Address: 84 Wakefield Road Huddersfield HD8 0BL

Application number: 2024/92112	
What is the application for?:	Demolition of existing dwelling and erection of replacement dwelling
Address of the site or building:	74, Wakefield Road, Lepton, Huddersfield, HD8 0BL
Postcode:	HD8 0BL

Rev	Date
Drawing Proposed Plans, Site Plan and Elevations	
Drawing no:	Rev Date Scale @ A1
0156/2023-03	May 2024 1:100 / 1:200
Client Mr S Carter Waller	
Job title Replacement Dwelling, 74 Wakefield Road, Lepton, Huddersfield

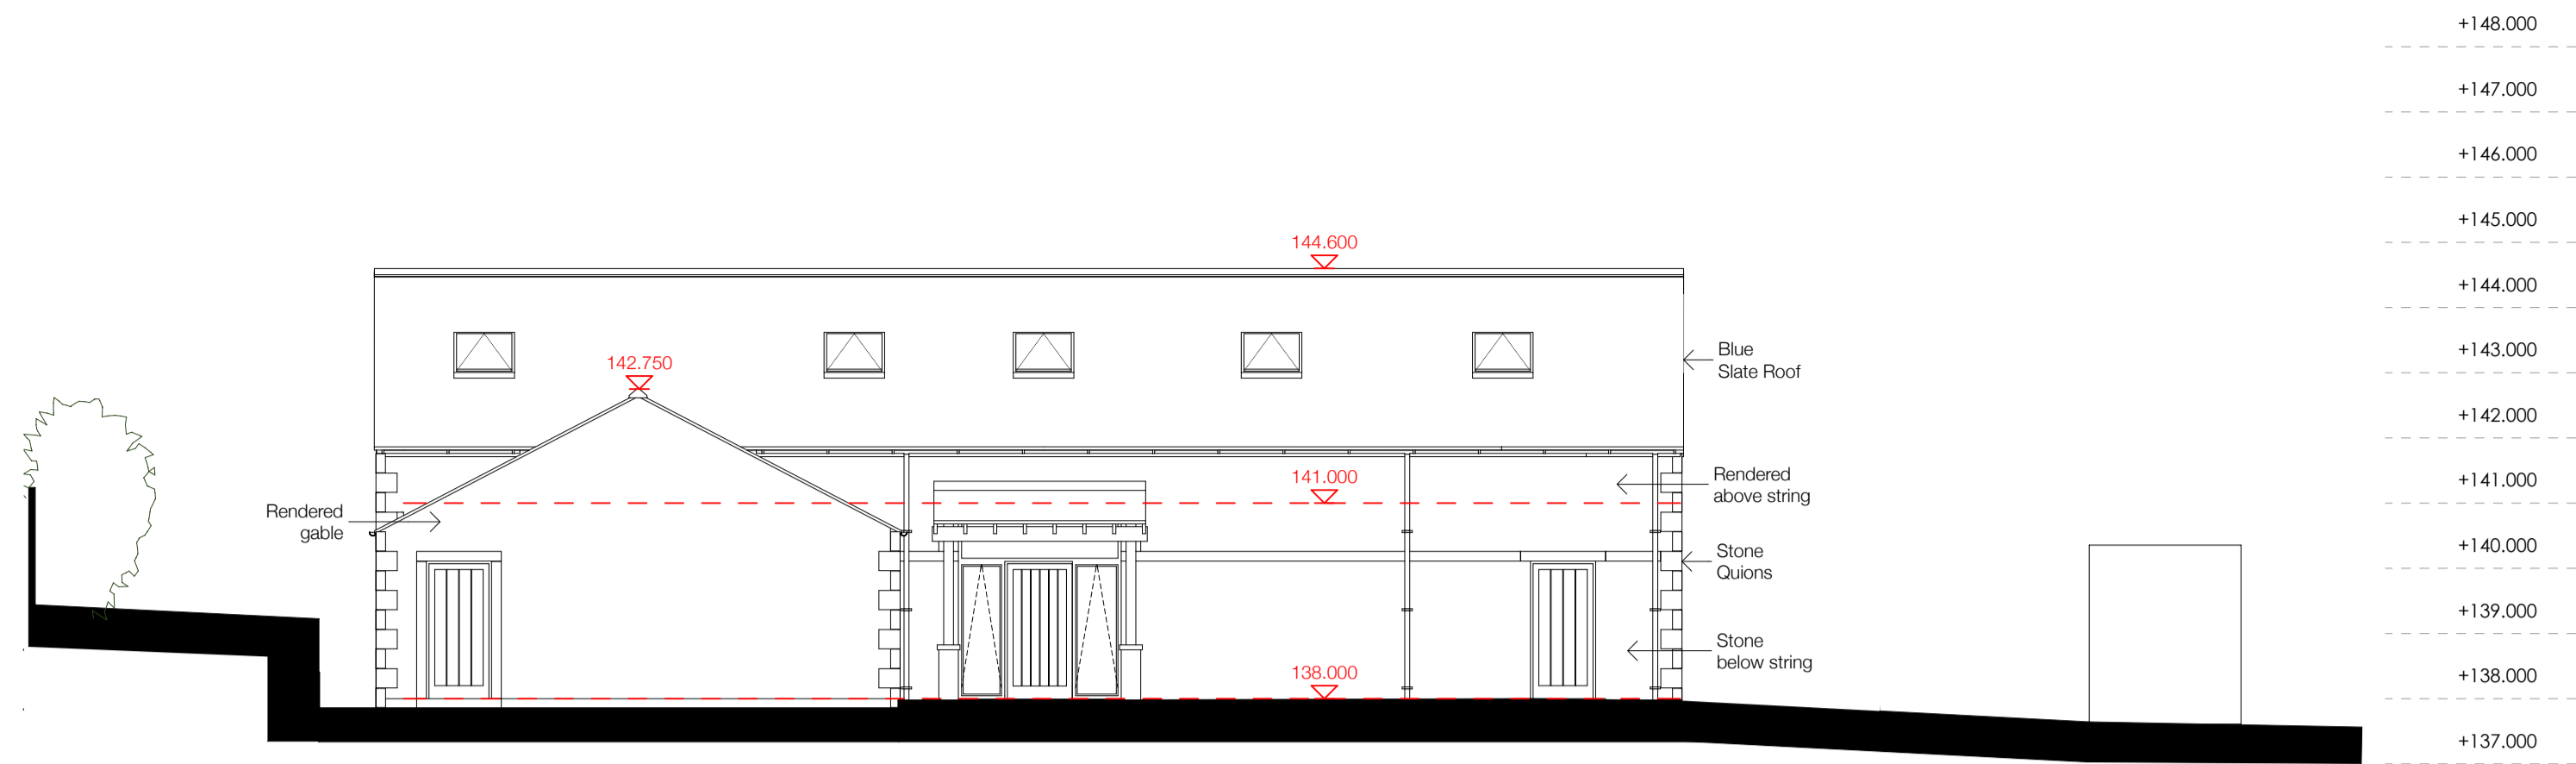
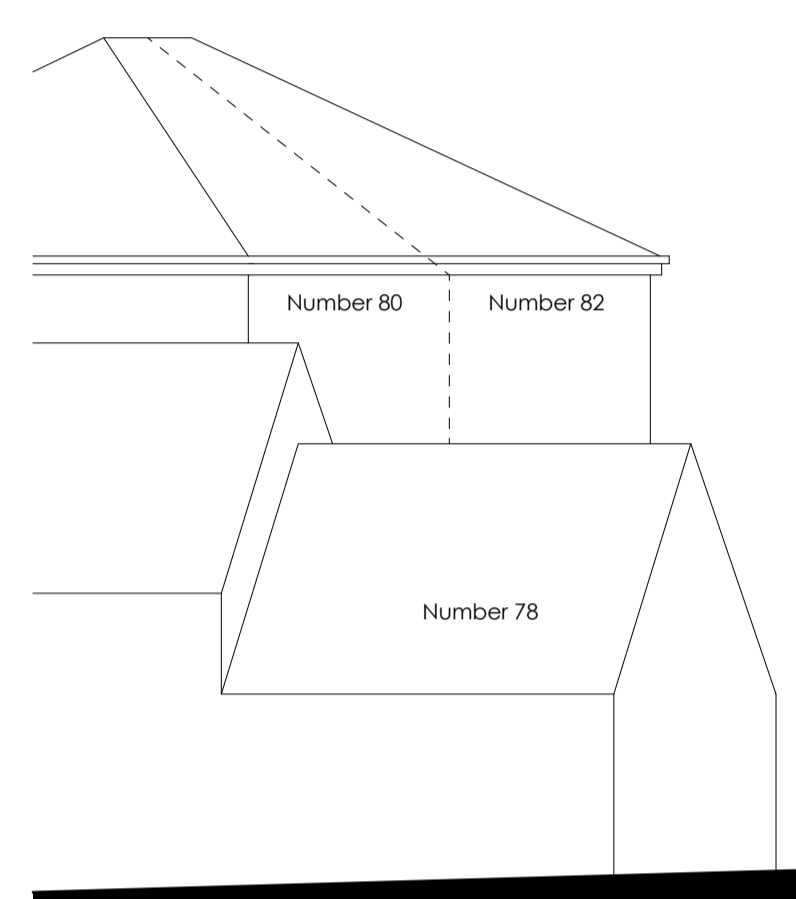
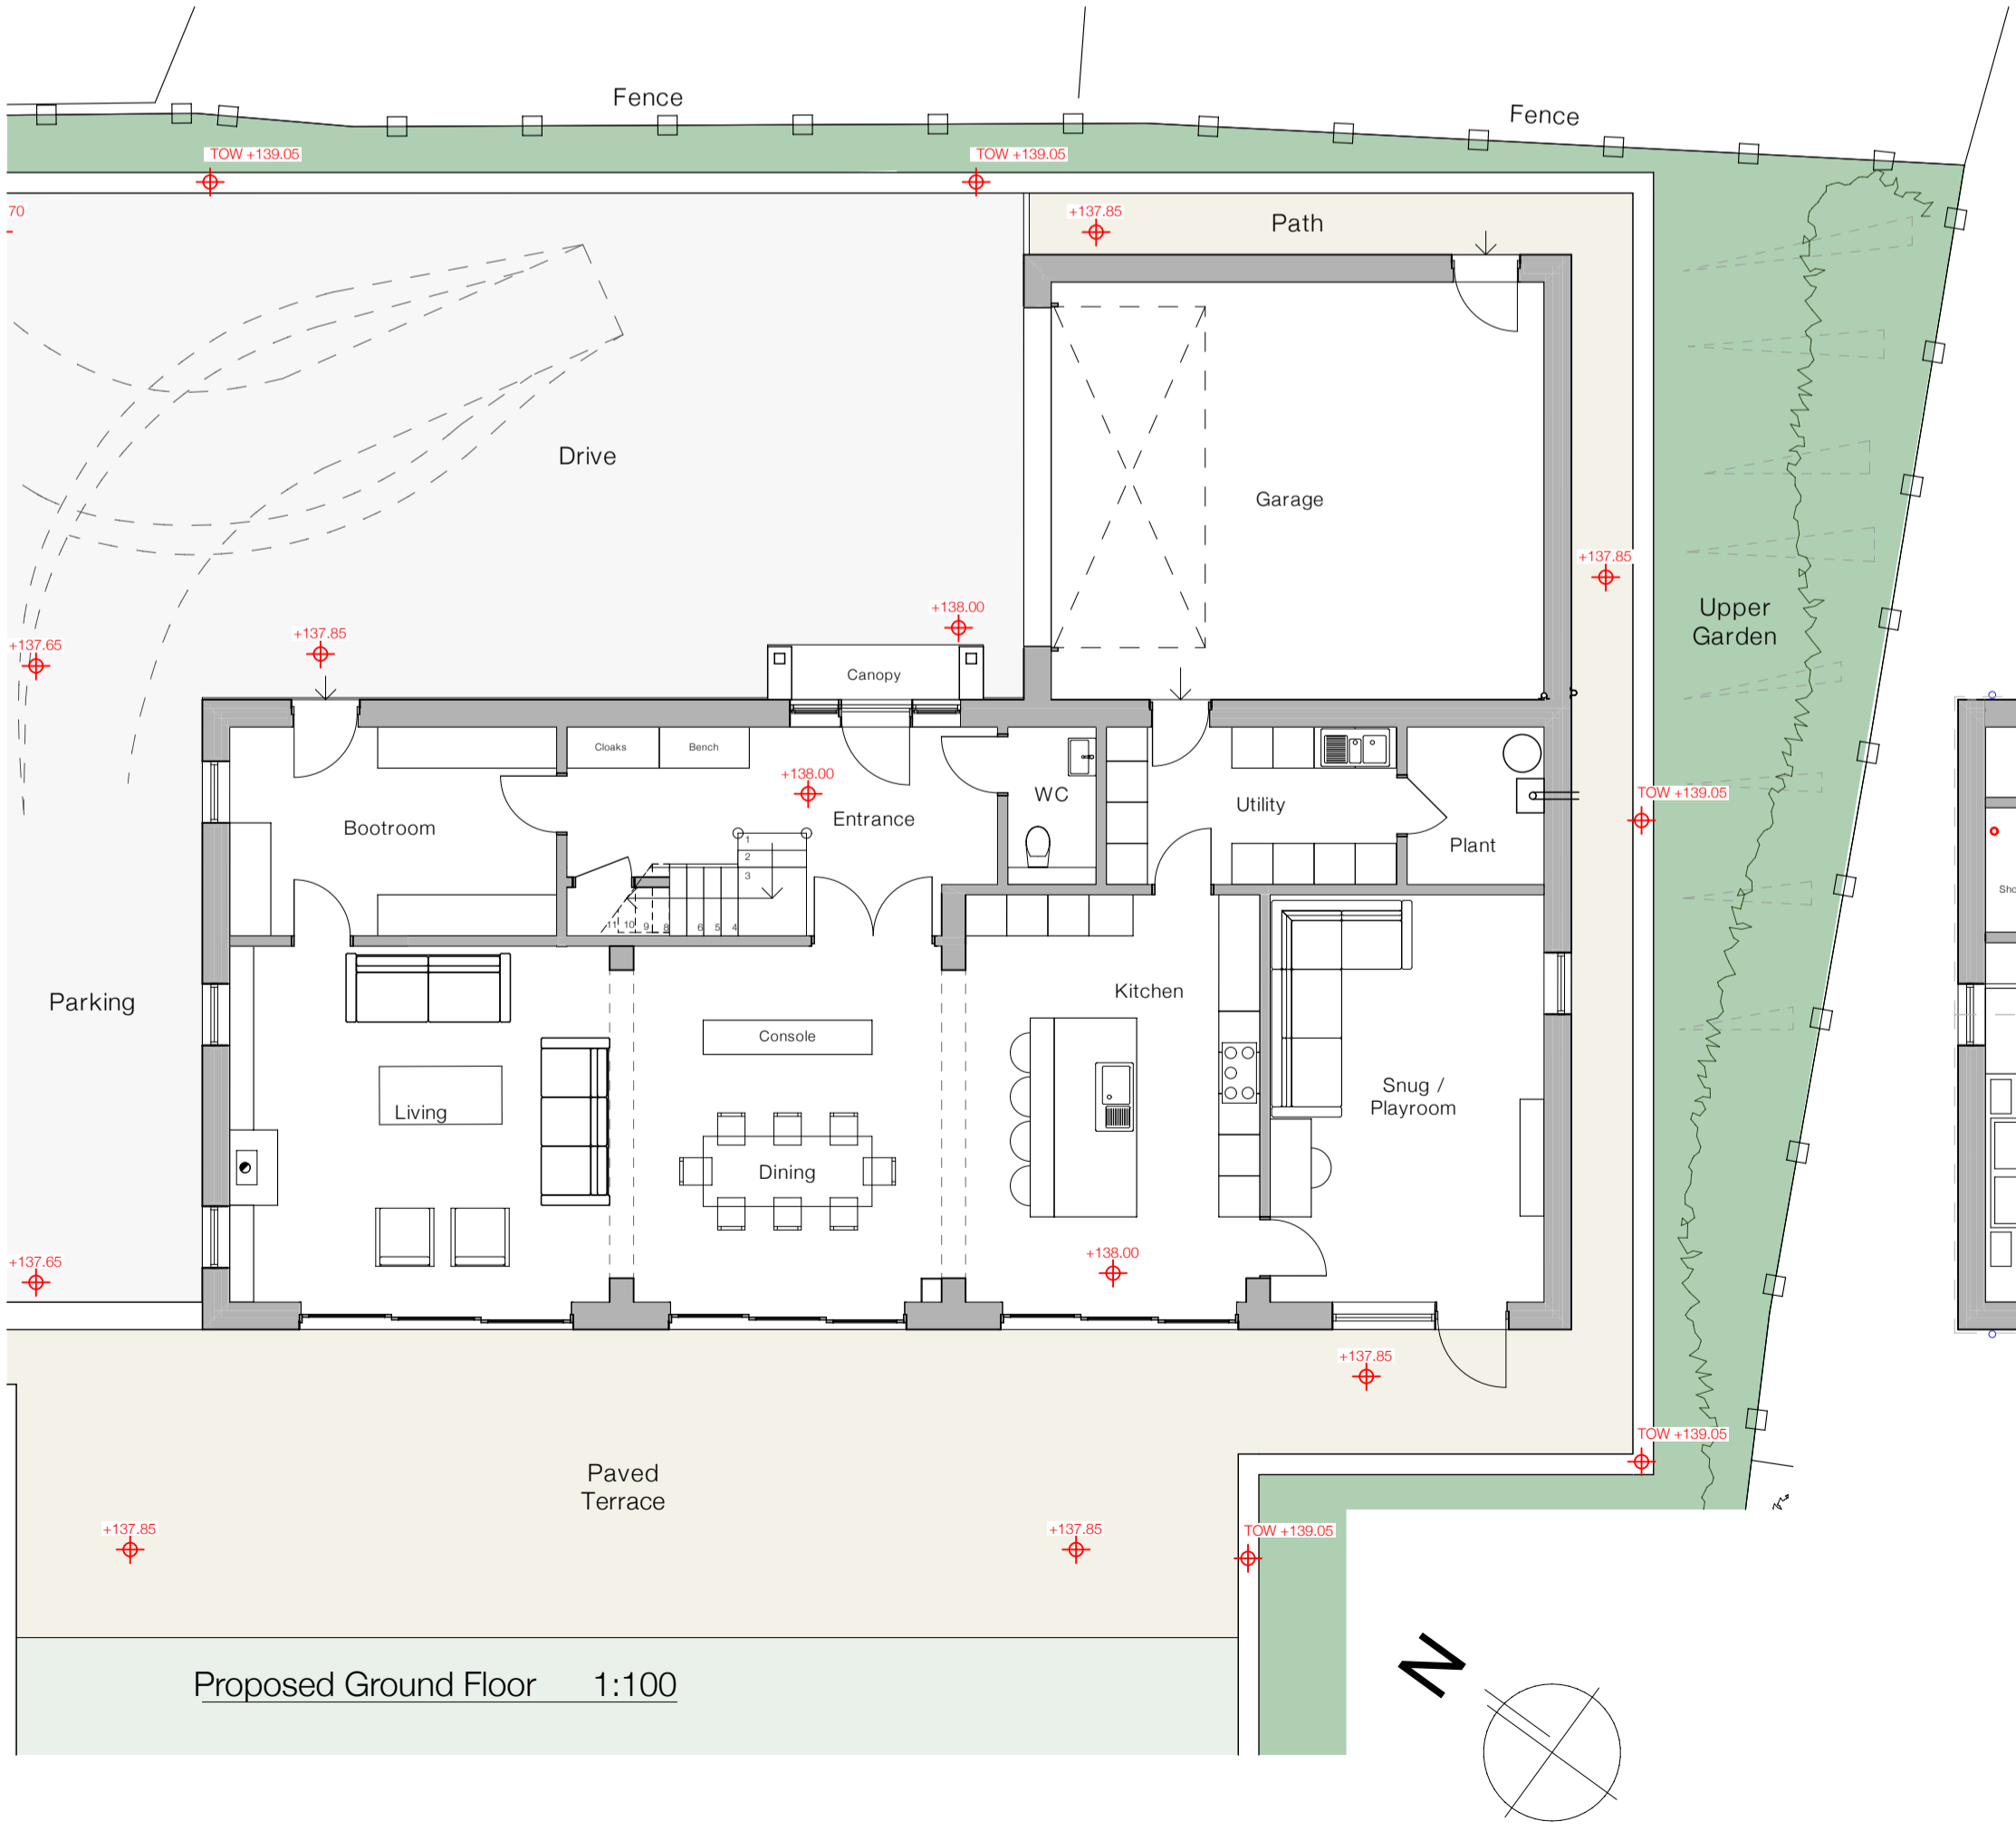
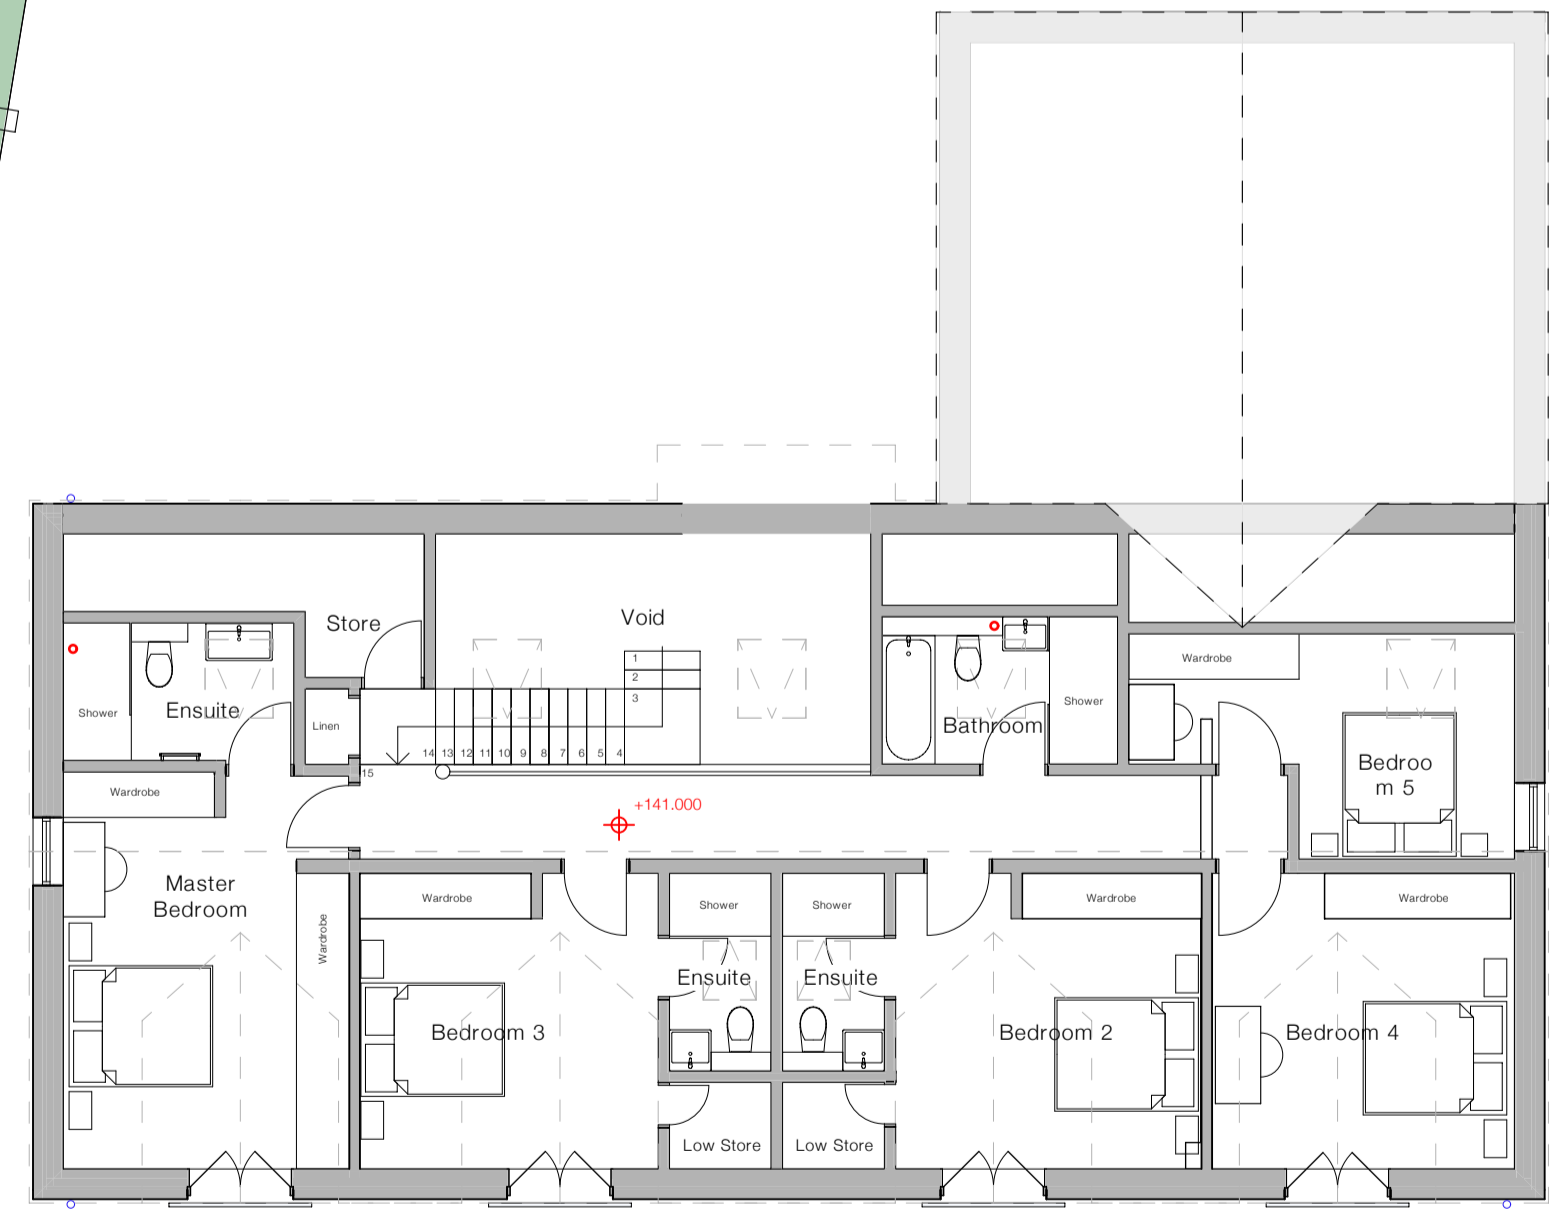
Type of comment: An objection	
Do you wish your comments to be published on the website anonymously?	No
<p>Having reviewed the existing & proposed plans for the dwelling, I have identified several risks that it poses on the neighbouring properties & wildlife.</p> <p>The report from the Coal Authority and Enviro both indicate "substantive" concerns of subsidence at "moderate to high risk". Due to the proposed proximity to my property, this poses a high risk of subsidence on my property also.</p> <p>The proposed plans show a two storey property with bedrooms overlooking my property, imposing on my privacy. Due to the close proximity to the current boundary hedge, there is a risk of reduced light to the boundary hedge, lawn, trees & shrubbery. This will likely have an adverse effect on the wildlife.</p> <p>I am concerned regarding the proper disposal of waste from the development due to experience of disposal/burning of trade and/or domestic waste on neighbouring properties resulting in pollution onto my property.</p> <p style="text-align: center;">I am concerned about noise levels from the development. I note the condition (CSC1) from the Environmental Health response stipulating suitable working times.</p>
